22 April 2025

### **Arrangements for Handling Heritage Applications Direction 2021**

#### **MONKS HOUSE, BOURNE ROAD, SPALDING Application No. H16-0251-25**

02 | PROPOSED LOFT PLAN

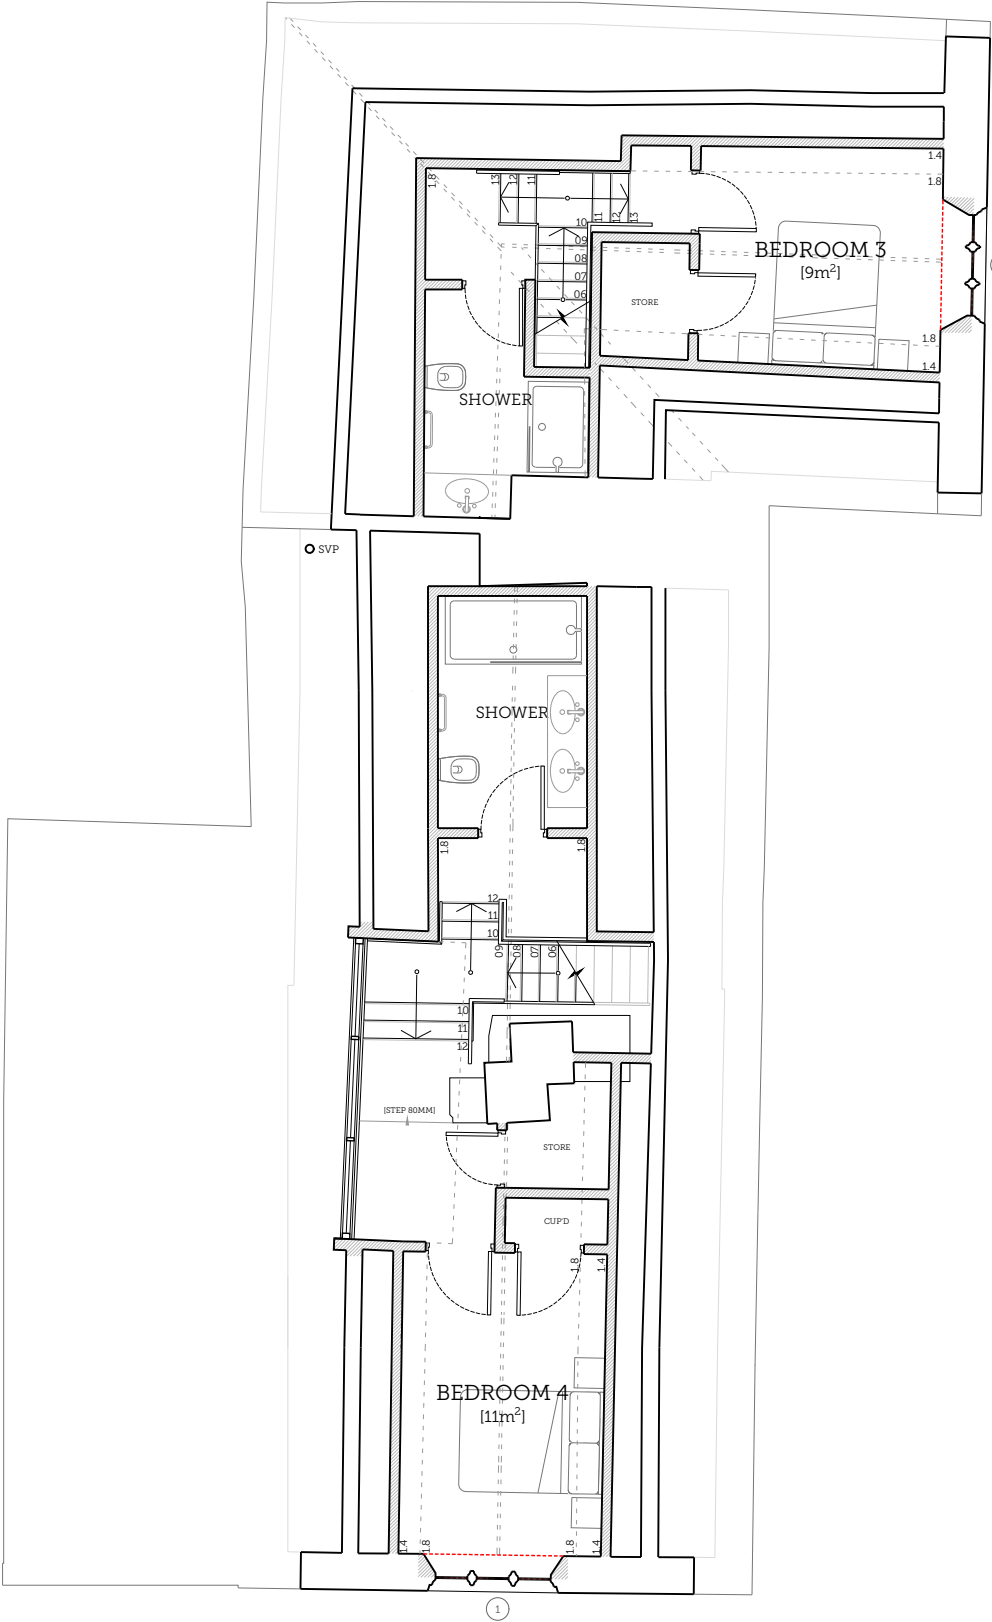
As noted in the Heritage Statement, the present external appearance of the house retains many of its original Tudor characteristics such as mullioned-windows and hood-mouldings. The proposed new dormer would cause harm to the significance of the building. This harm would be caused by visual impact.

Measurements of the proposed dormer have not been provided, however it appears to be extremely large and disproportionate in relation to all other existing apertures.

Proposed materials have also not been provided, however regardless of this, it is clear that the dormer would introduce a highly incongruous element to the historic context, not at all in keeping with the building's character, thus harming significance.

It is noted that the dormer is desired in order to facilitate staircase access to the proposed new Bedroom 4, however the benefit this would provide does not outweigh the harm that the dormer would cause.

The application also seeks to install two new staircases at first floor to provide loft access.

The Heritage Statement states that 'the proposed adaptions to the first floor are relatively simple with seemingly no loss of historic fabric'. However, no details of the proposed staircases or their impact on historic fabric has been provided.

It is recommended that the proposed dormer is omitted from proposals. We acknowledge that the dormer is required to facilitate a staircase in this location. If the staircase cannot be achieved without the dormer, we recommend that the staircase is

also omitted.

We encourage the consideration of other options instead of the staircase such as interconnecting the loft spaces if possible, alternative staircase locations, opening up just one part of the loft, or reconfiguring the layout at ground / first floors to allow for the desired further bedroom accommodation there instead of in the loft.

It is also recommended that further detail is provided about works to install the new staircase(es), the ground floor window replacement, and the associated impacts on historic fabric.
